**KIRKLEES METROPOLITAN COUNCIL  
INVESTMENT & REGENERATION SERVICE**

**DELEGATED DECISION TO DETERMINE PLANNING APPLICATIONS**

Reference No:	<b>2024/62/92465/E</b>
Site Address:	9, Hollybank Avenue, Upper Batley, Batley, WF17 0AQ
Description:	Erection of extensions and alterations
Recommending Officer:	Jennifer Booth

**DECISION – Full Conditional Permission**

DRG:  
PROPOSED FLOOR PLANS & ELEVATIONS

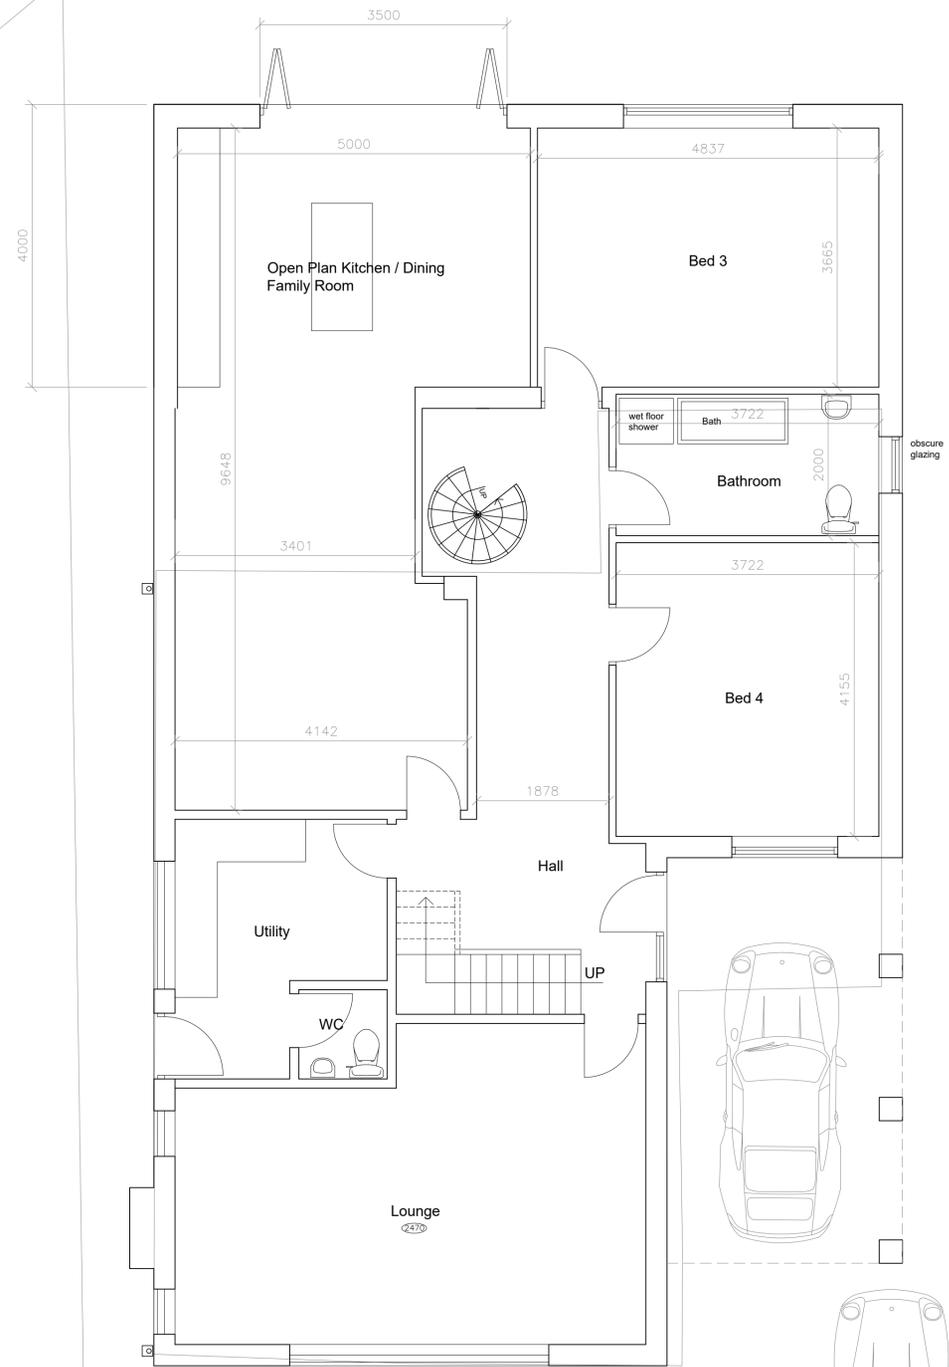
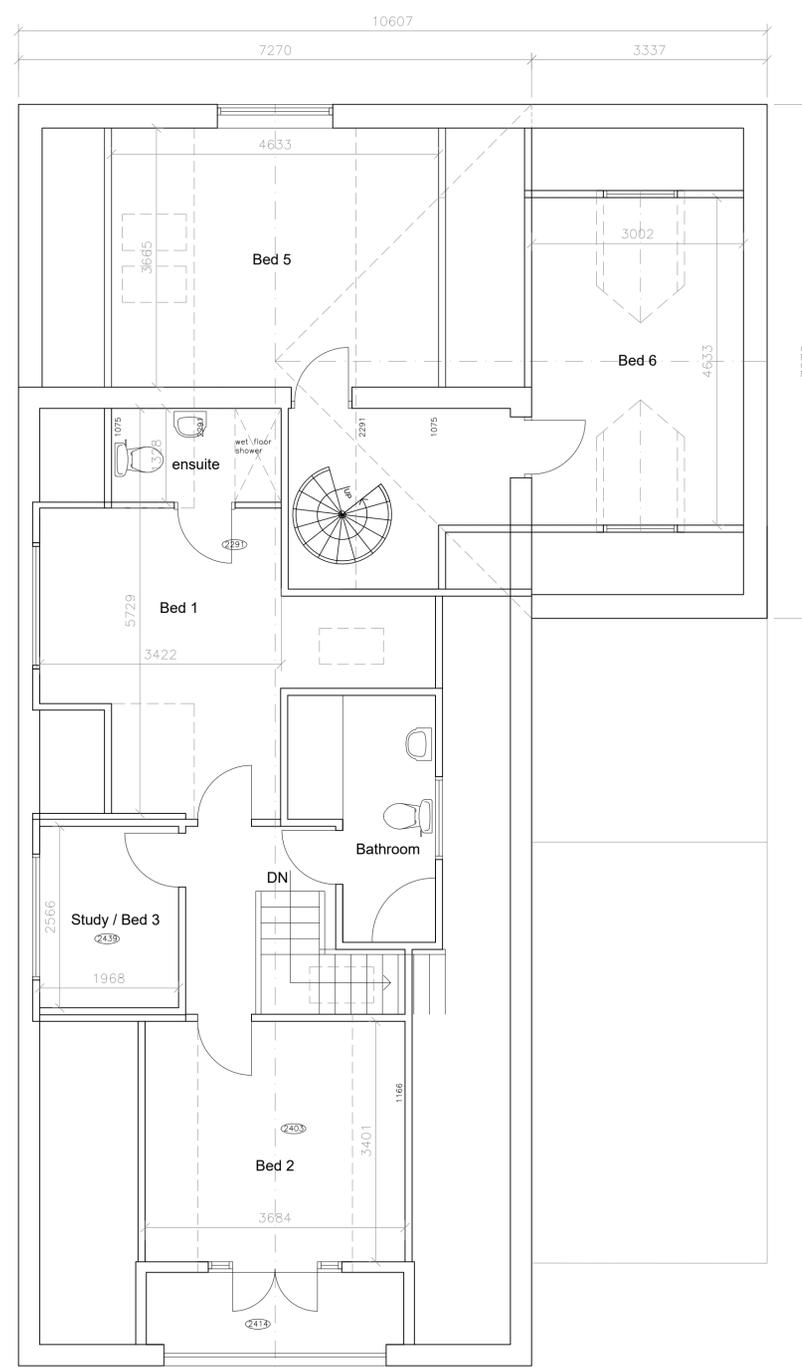
The plans show a second dormer in the opposite side elevation which has been amended to serve a bathroom.

The property has a modest drive at present. The proposals are to widen the parking area to ensure an adequate parking provision whilst retaining the majority of the garden area. The layout appears to be in line with the SPD.

The proposals will result in some intensification of the domestic use. However, the submitted plans show parking to the front and under the car port for at least three vehicles which is considered to represent a sufficient provision. Bin storage for the dwelling would not be moved as part of the proposals. As such the scheme would not represent any additional harm in terms of highway safety and as such complies with Policy LP22 of the Kirklees Local Plan along with Key Design Principles 15 & 16 of the House Extensions & Alterations SPD.

- Parking  
**Officer Response:** *An amended plan has been provided which demonstrates parking for 3-4 vehicles which is in compliance with the requirements set out in the House Extension & Alterations SPD.*

The initially submitted plans raised concerns in terms of privacy with respect to the new dormer window which would have served bedroom 1 and the proposed parking. Amended plans have been received which amended the upstairs layout so the new dormer would serve a bathroom and bedroom 1 has been moved to the opposite side of the property along with showing a revised parking layout. The proposals have not increased the level of development and as such, the amended plans have not been advertised.
